**Consultation Response from KC,  
Lead Local Flood Authority**

**2023/91870 Rough Nook Farm, 112, Mill Moor Road, Meltham, Holmfirth, HD9 5LW**

**Discharge conditions 2 and 3 (materials), 4 (retaining walls), 5 (drainage), 6 (watercourses), 8 (temporary surface water drainage), 9 (outfall details), 10 (adoptable road details), 12-16 Phase 1 & 2 Ground Investigation Reports), 17 (EV charging points), 18 (construction traffic), 20 (EDS) on previous permission 2018/94006 for variation condition 2 (plans/specification) on previous permission 2017/93015 for erection of 19 dwellings (C3) with associated parking with vehicular access**

**Date Responded: 1<sup>st</sup> August 2023  
Responding Officer: Paul Farndale  
Responding Ref:**

Drawing No: B21967-D-316

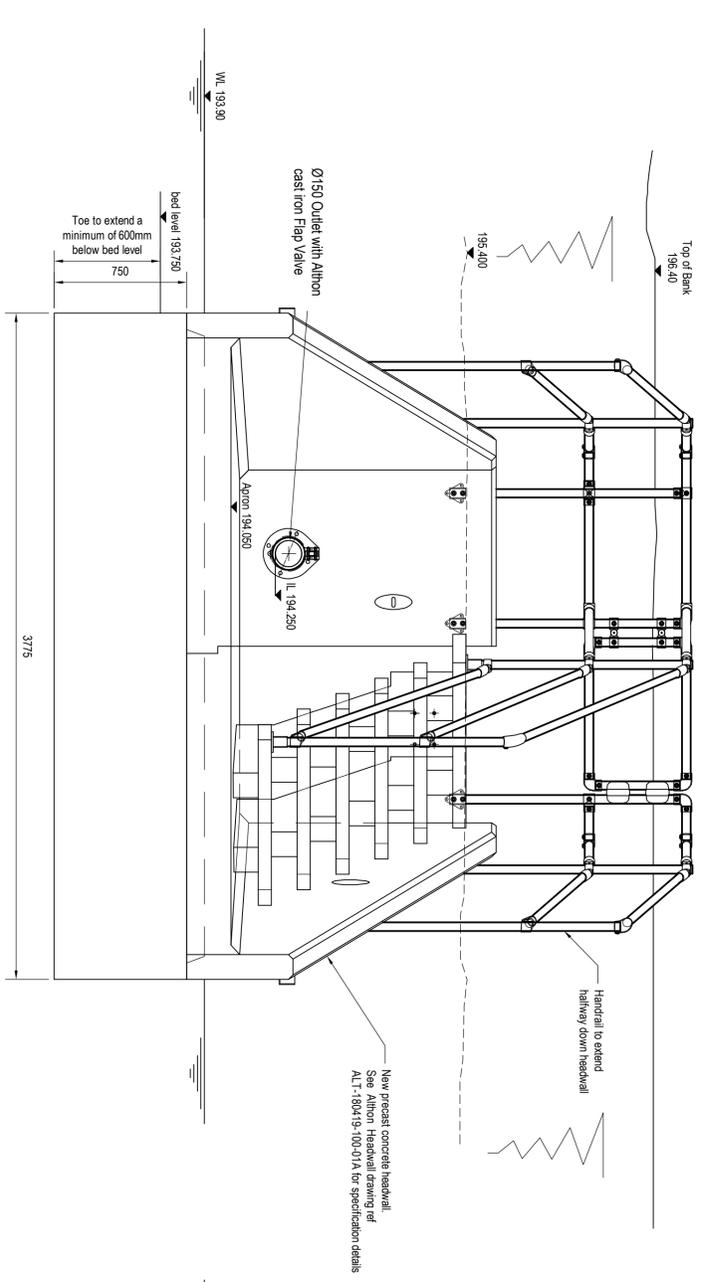
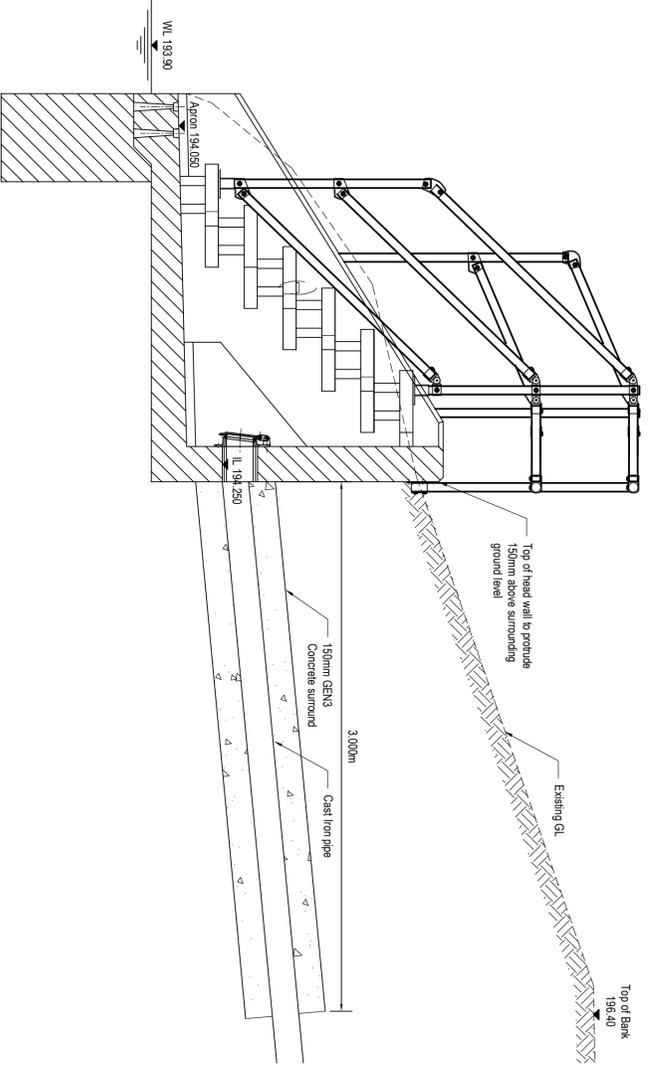
Kirklees LLFA is satisfied that drawing reference B21957D-316B achieved consent to construct.

**We can recommend that this condition can be discharged.**
